<b>Your Ref</b>	SSD-10416
<b>Our Ref</b>	NCA/2/2020
<b>Contact</b>	Paul Sartor
<b>Telephone</b>	9806 5740
<b>Email</b>	<a href="mailto:psartor@cityofparramatta.nsw.gov.au">psartor@cityofparramatta.nsw.gov.au</a>

**20 June 2022**

**COUNCIL SUBMISSION  
NOTICE OF EXHIBITION OF RESPONSE TO SUBMISSIONS REPORT FOR THE  
PARRAMATTA POWERHOUSE (30B PHILLIP ST, PARRAMATTA)**

1 PROPOSED ELEVATION S  
1 : 100

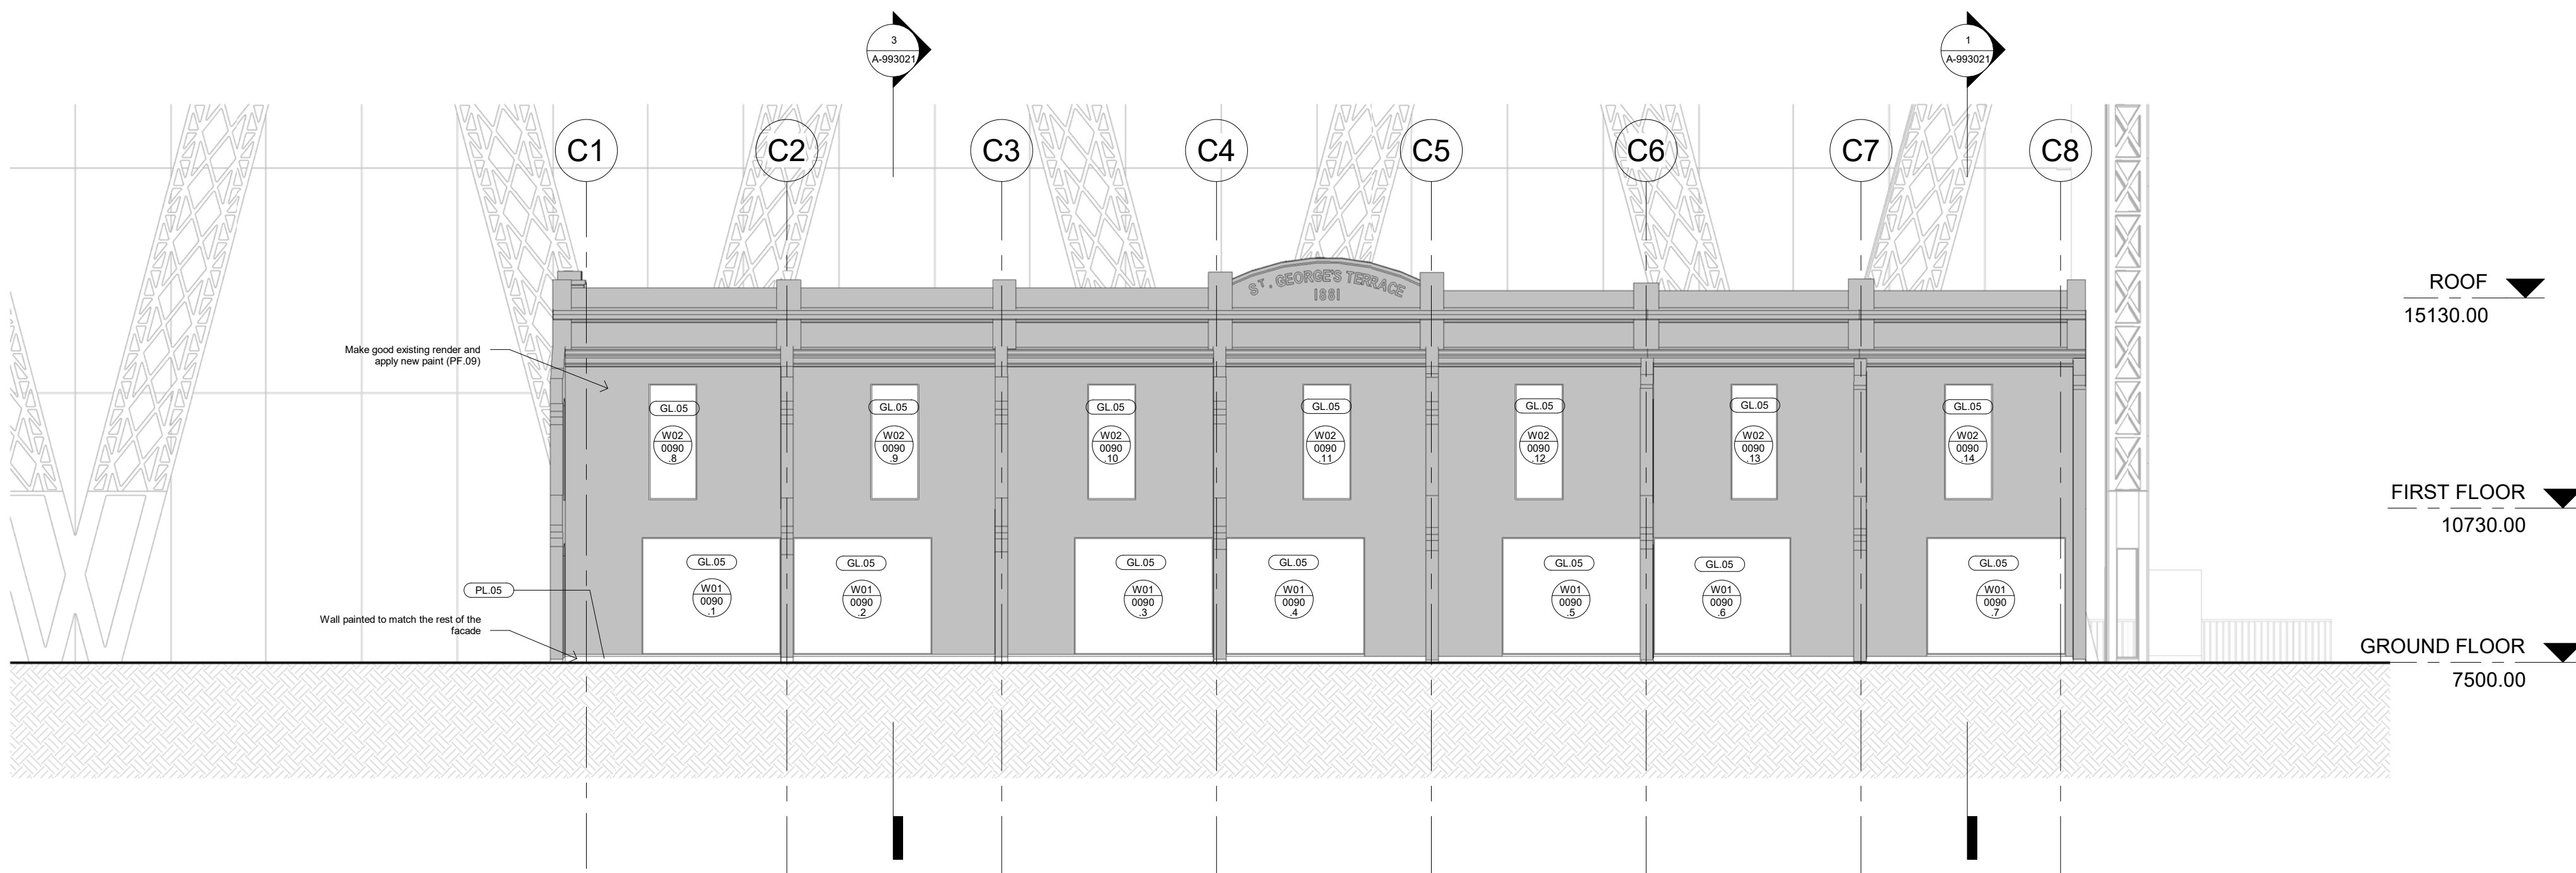
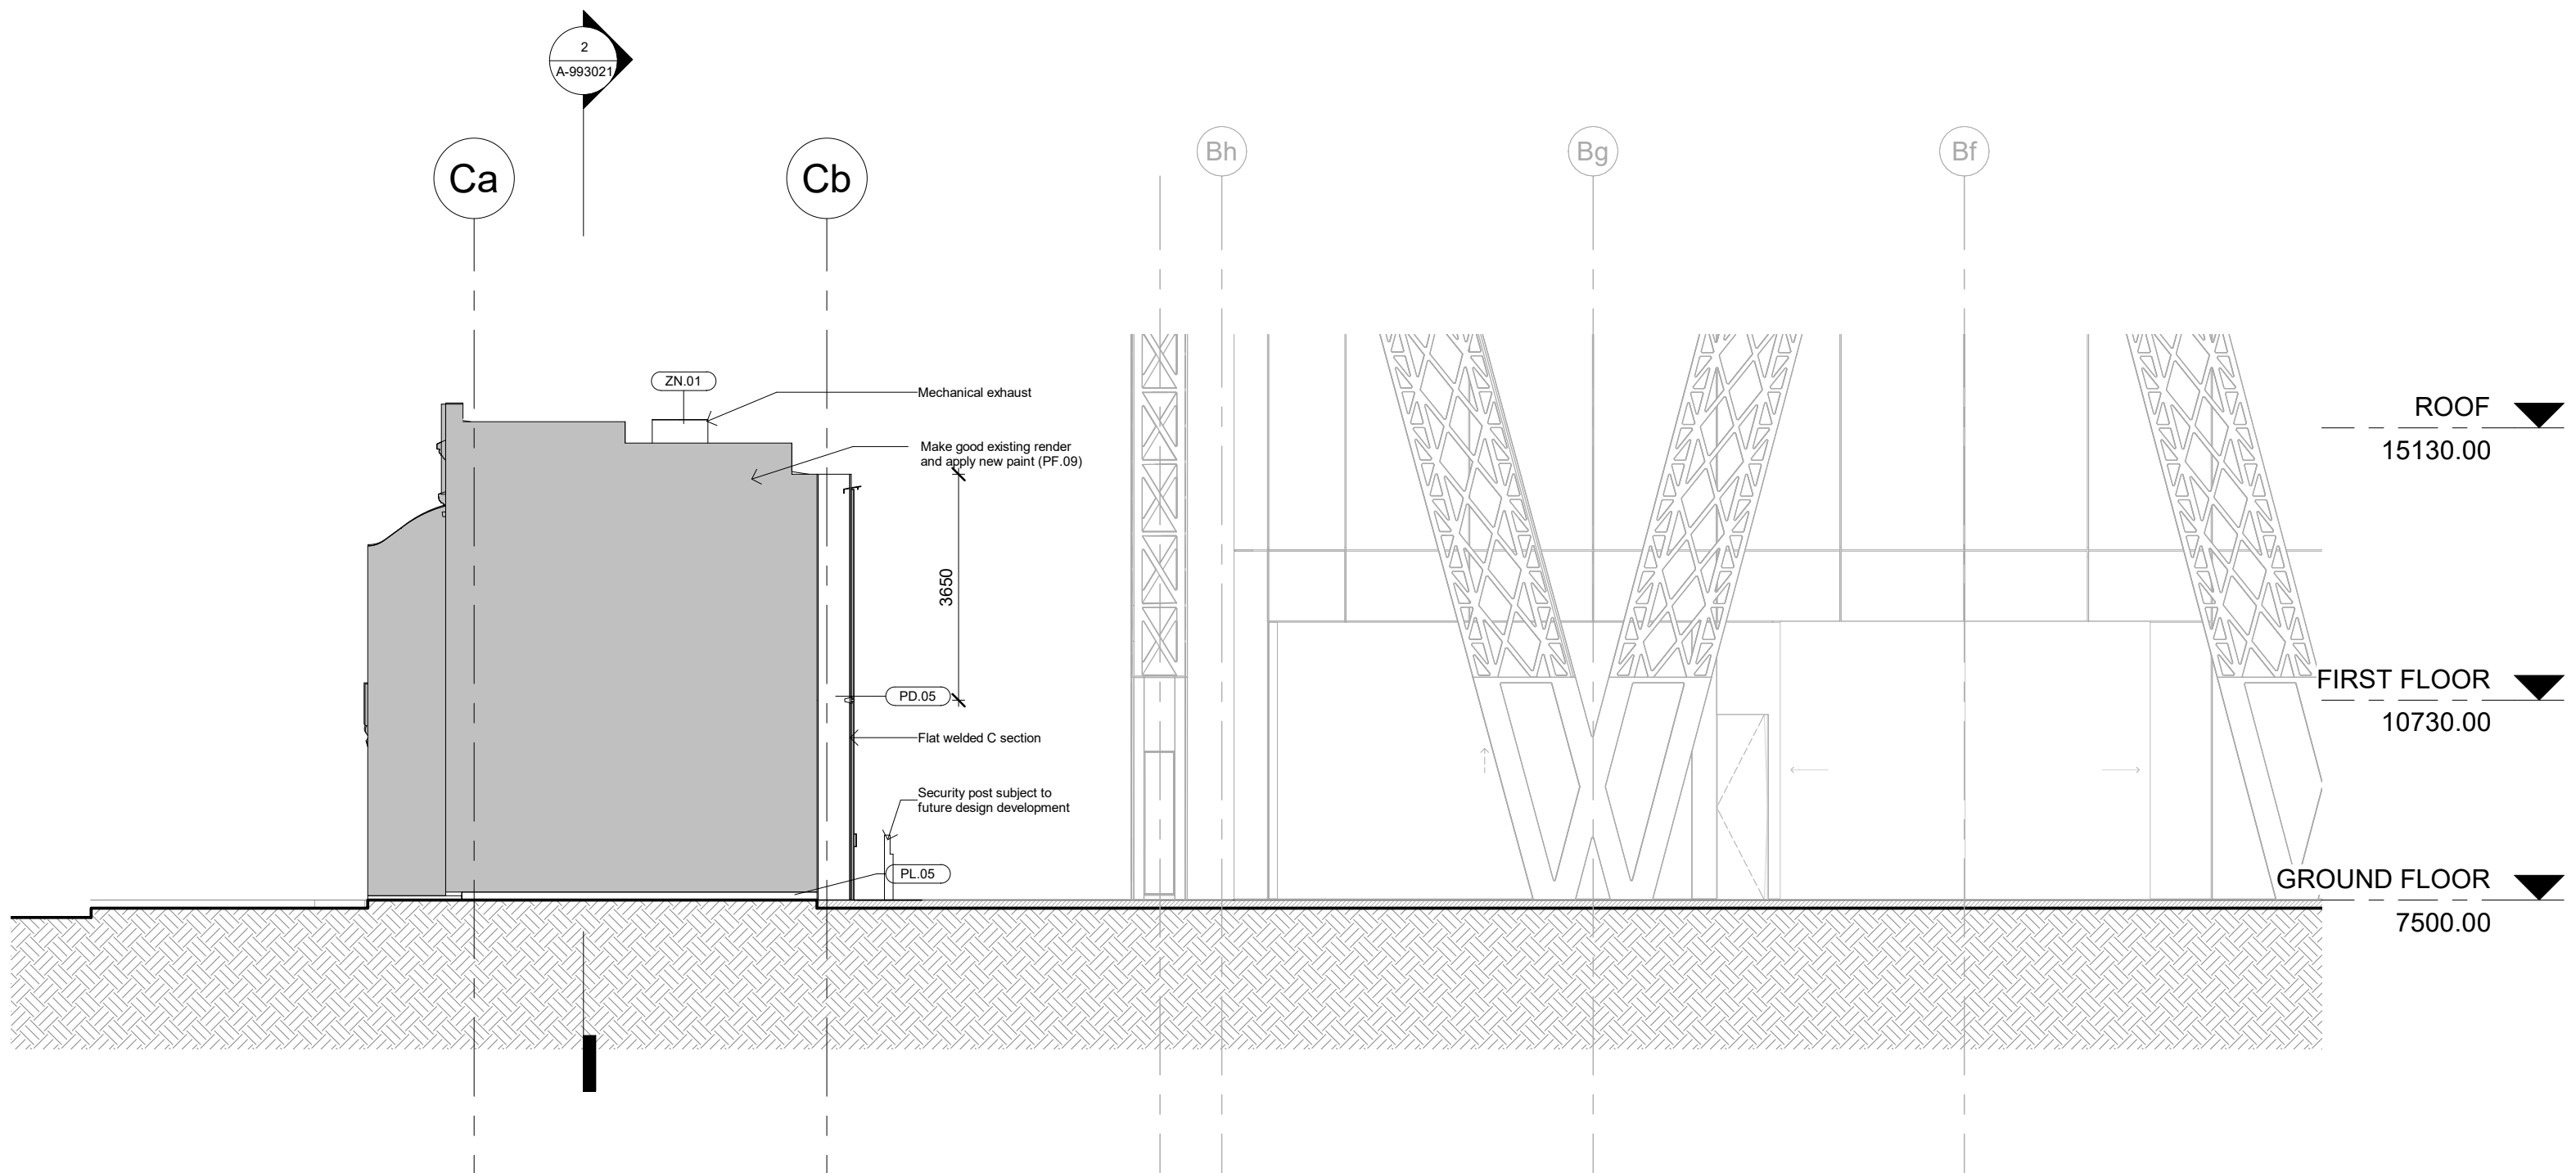
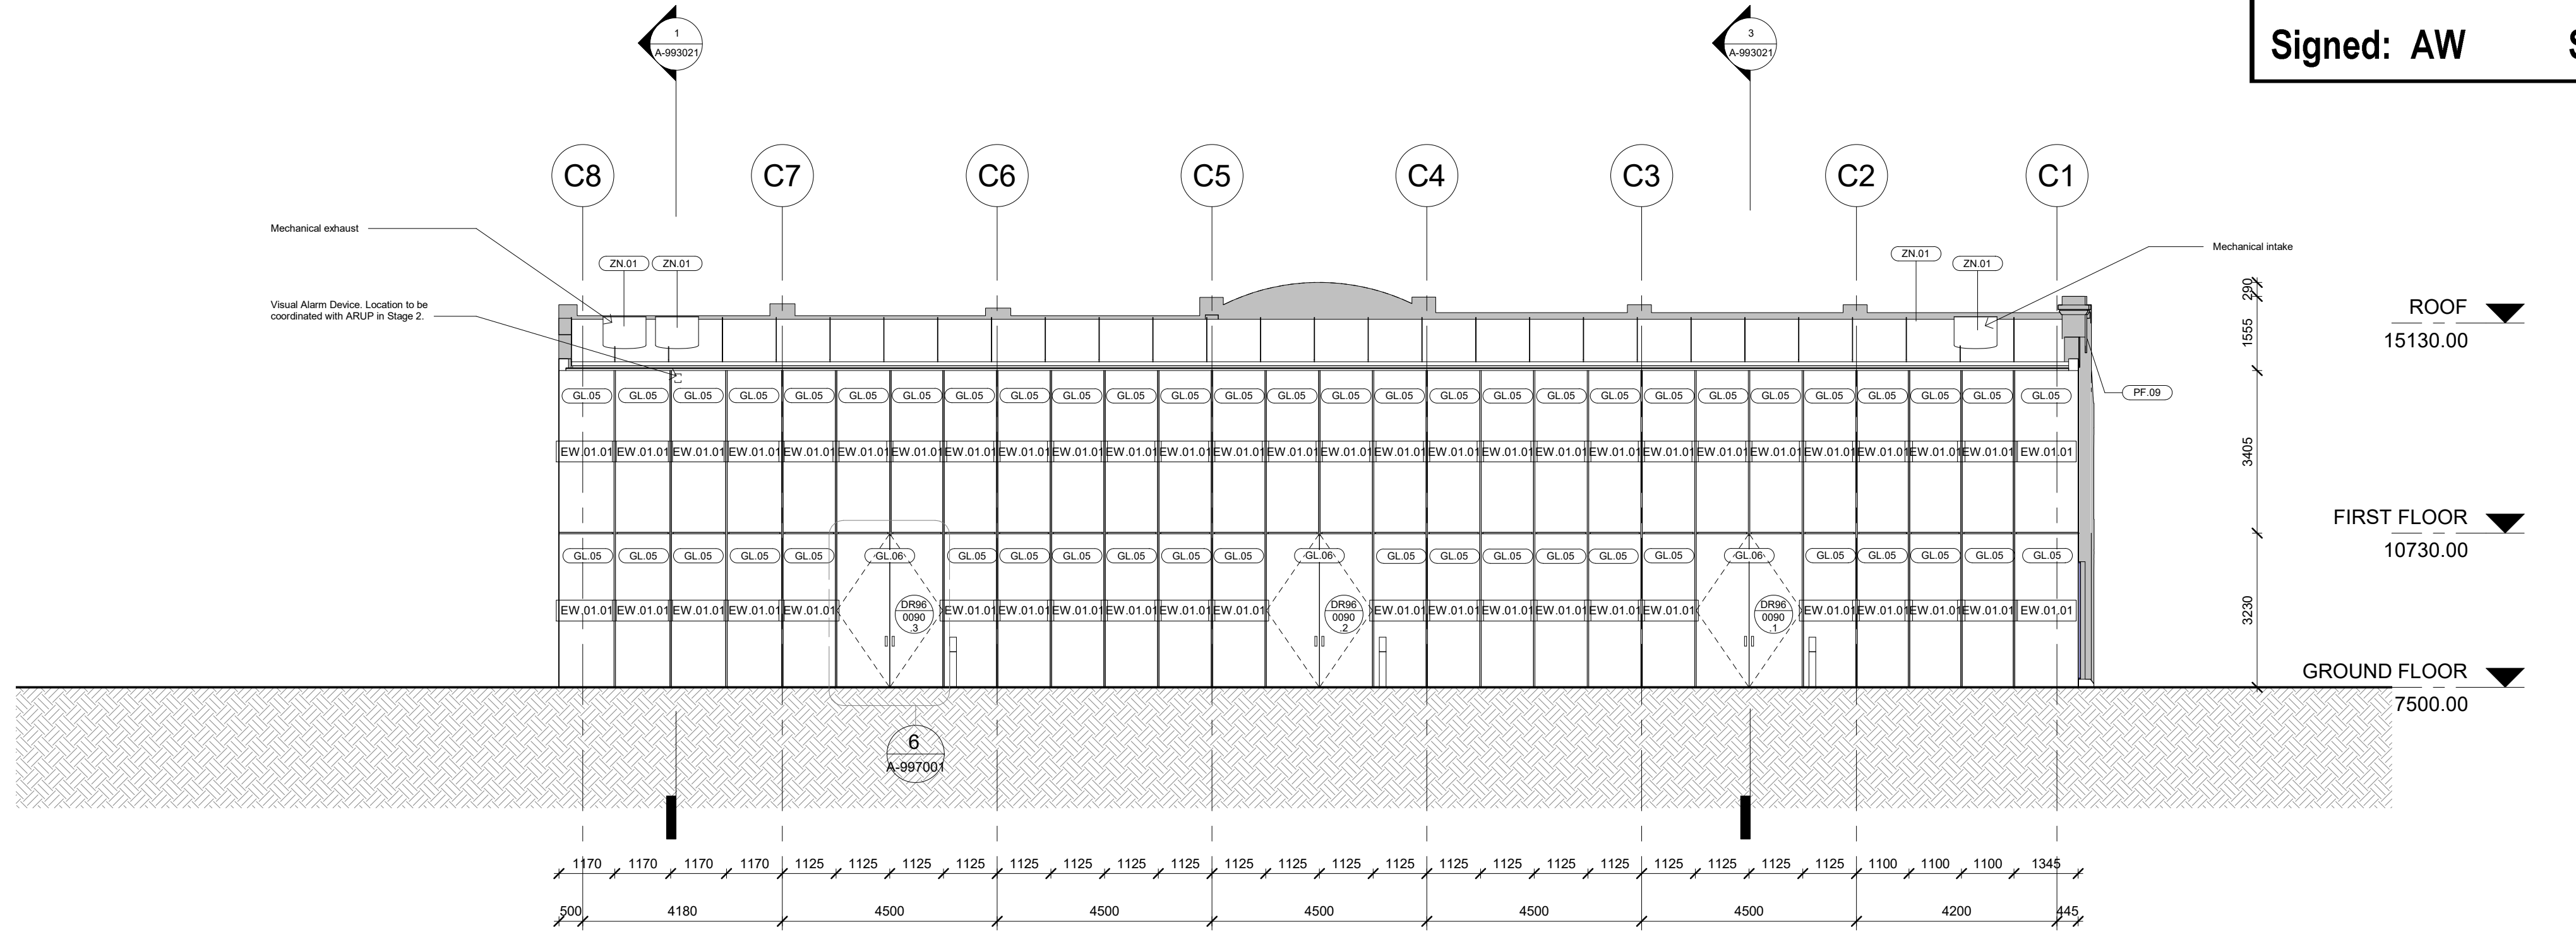
- The large and generous opening at the rear and the removal of the chimneys together with the missing interpretation and reinstatement of the Victorian street presentation (veranda and balconies) of this row would completely change the street frontage presentation by creating a confusing reading of the existing proportions.
- The applicant is concerned that Council has requested changes to the doors and windows that would appear as an imitation. This is not the case, Council requests a design inspired by the Victorian proportions that would allow an appropriate interpretation of the original façade prior to the unsympathetic 1970s changes. The new elements requested are not supposed to appear as an imitation.

- The veranda reinstatement would make a significant contribution to the street view and overall heritage preservation. St George Terraces are a rare example of its typology of terraces within the Parramatta LGA and Parramatta CBD and should be restored to its maximum potential.
- The paving to the front of the terraces should also be differentiated from the rest of the development floor treatment. This should be seen not as a limitation but as an opportunity for heritage interpretation.
- Respectful preservation and appropriate interpretation of the original façade features are required to achieve an exemplary sample of heritage adaptive reuse of the existing and remaining of the Victorian heritage façade.
